Permitting and Inspections Department
Michael A. Russell, MS, Director

CBL: 012 A009001
Located at: 133 ANDERSON ST

Inspection Violations

Owner/Manager PENINSULA COMMUNITY LP		Inspector Jason Duval	Inspection Date 2/20/2018
Location 133 ANDERSON ST	CBL 012 A009001	Status Failed	Inspection Type Inspection

|                      |                 | Plan: <b>SPRINKLER BASEMENT</b> | Page: <b>24A</b>    |

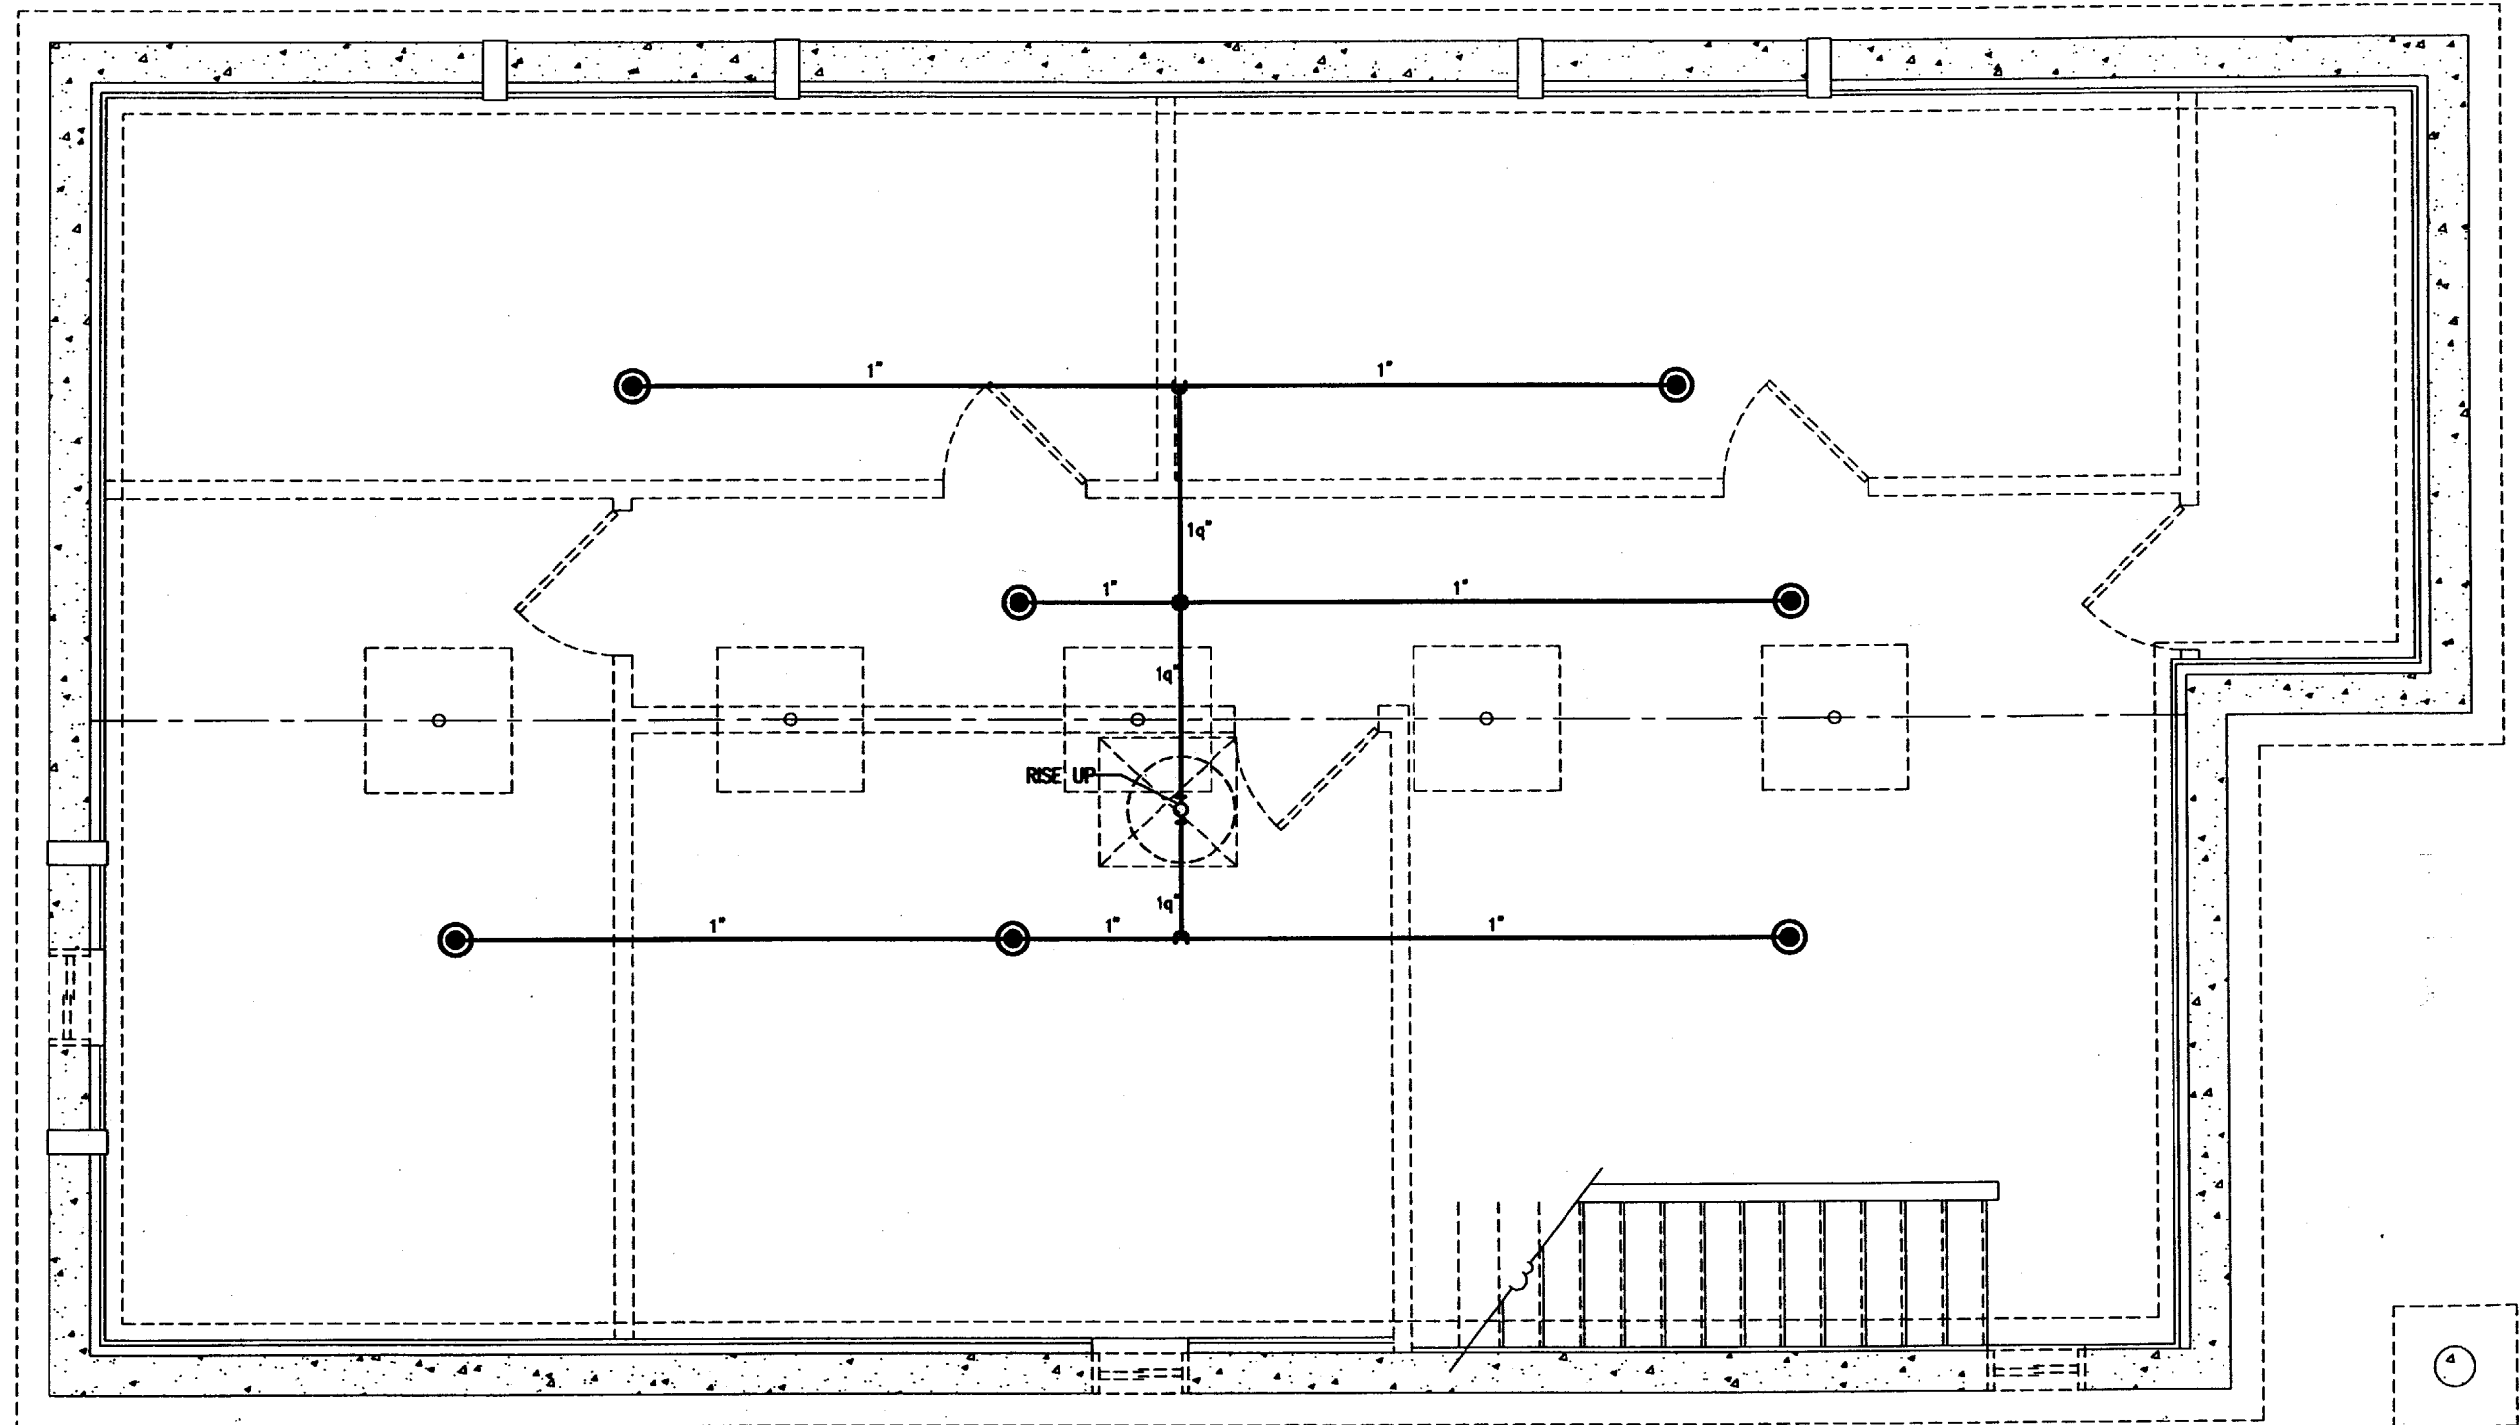
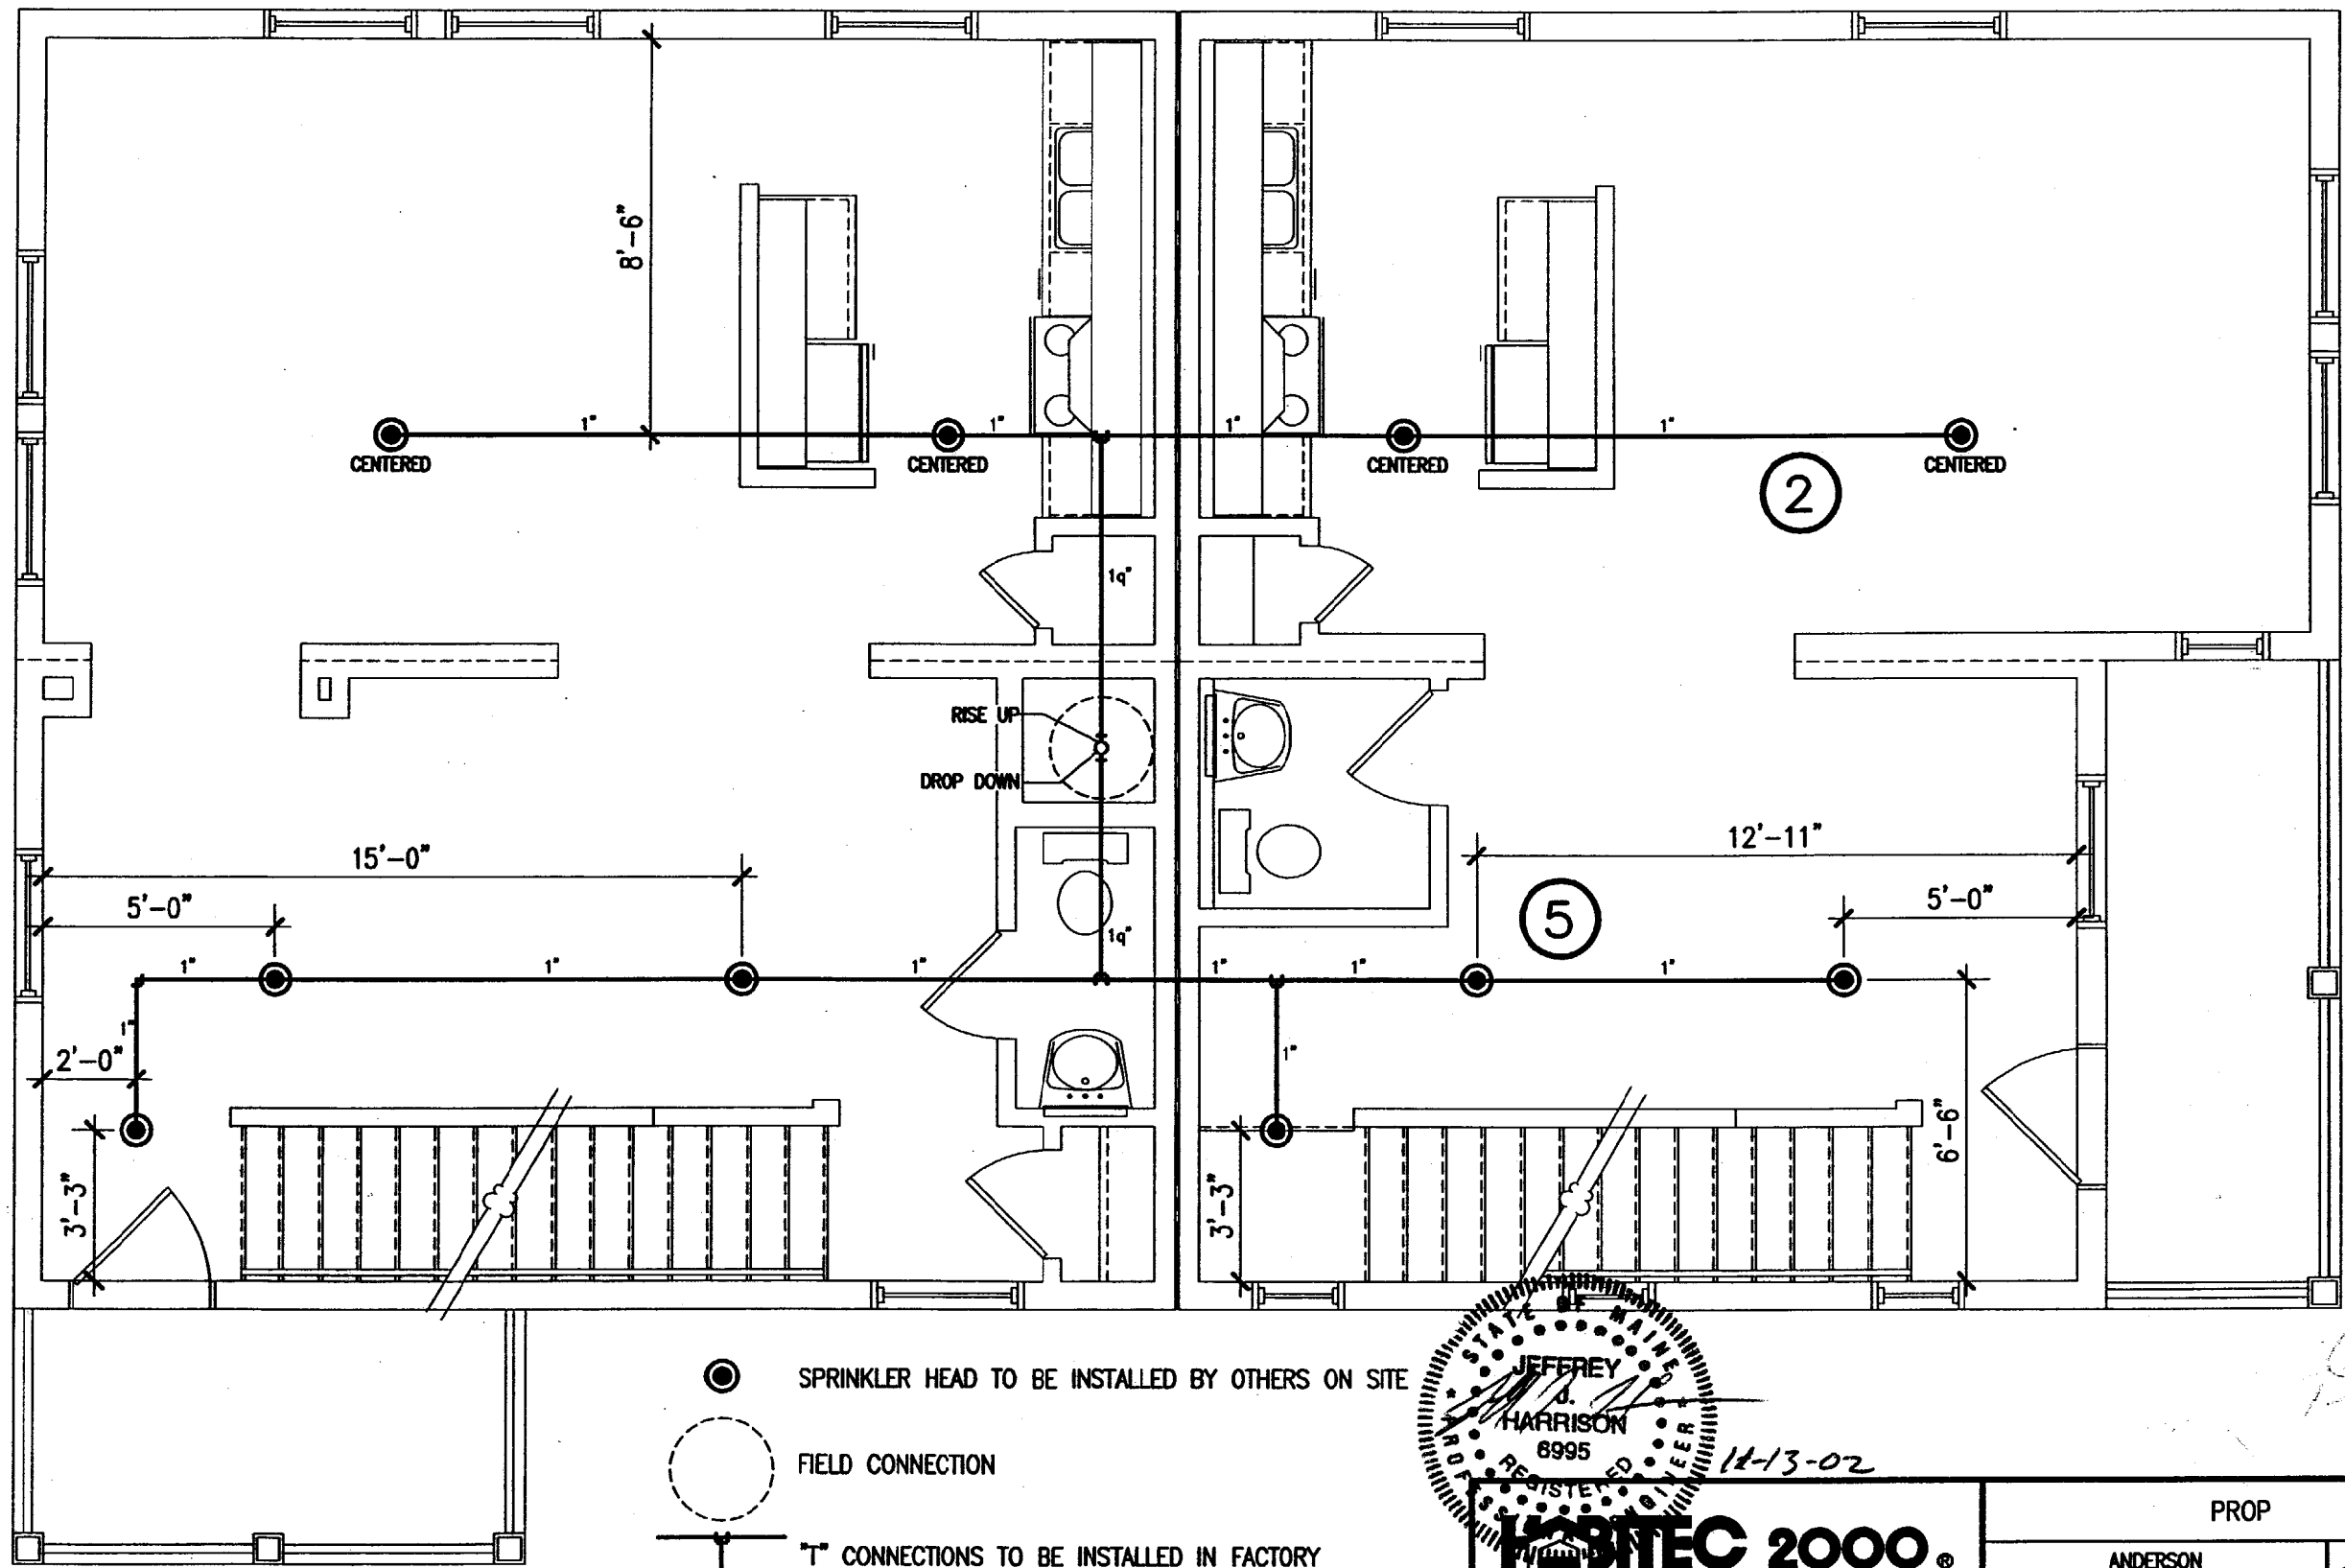
Notes: Sprinkler required for boiler protection.

Comments: Field Inspection 2/20- Basement area requires a CO alarm. Sprinkler required for boiler protection.

133 ANDERSON STREET

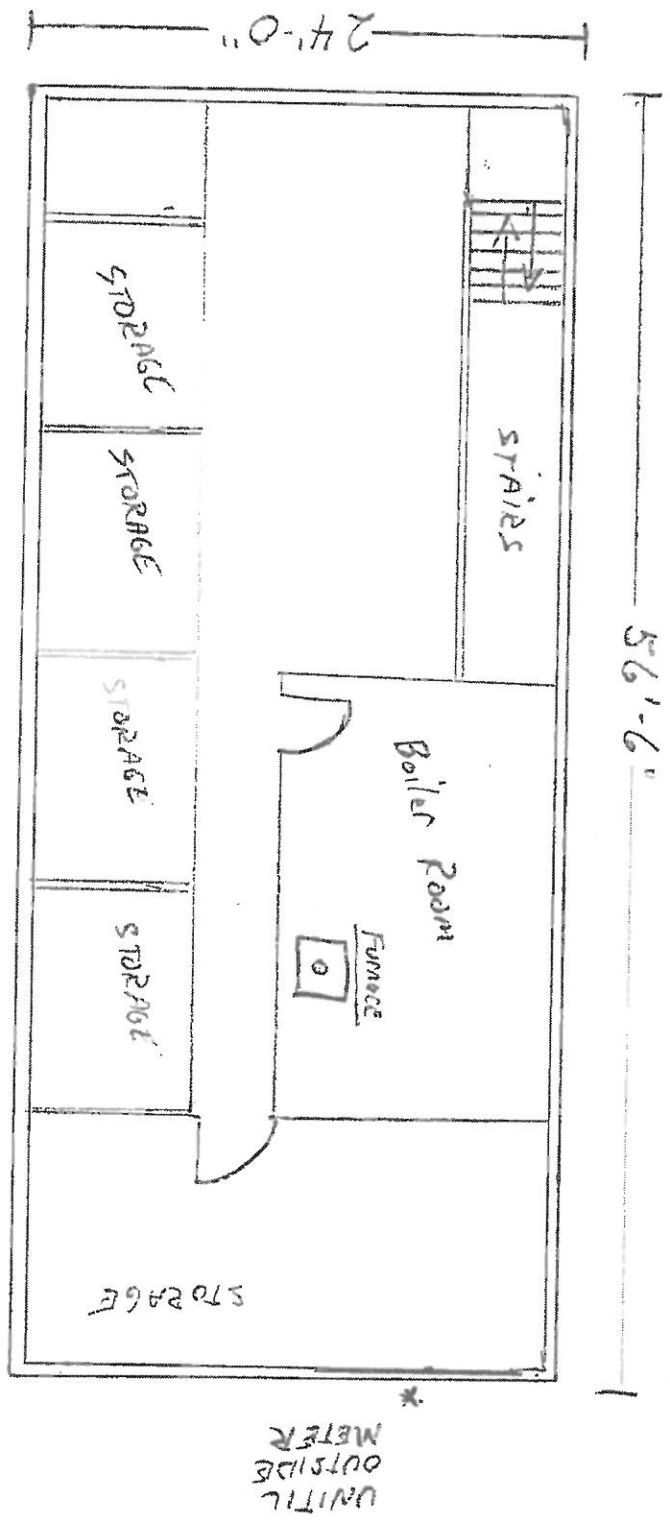
Notes: CO alarm required in basement area.
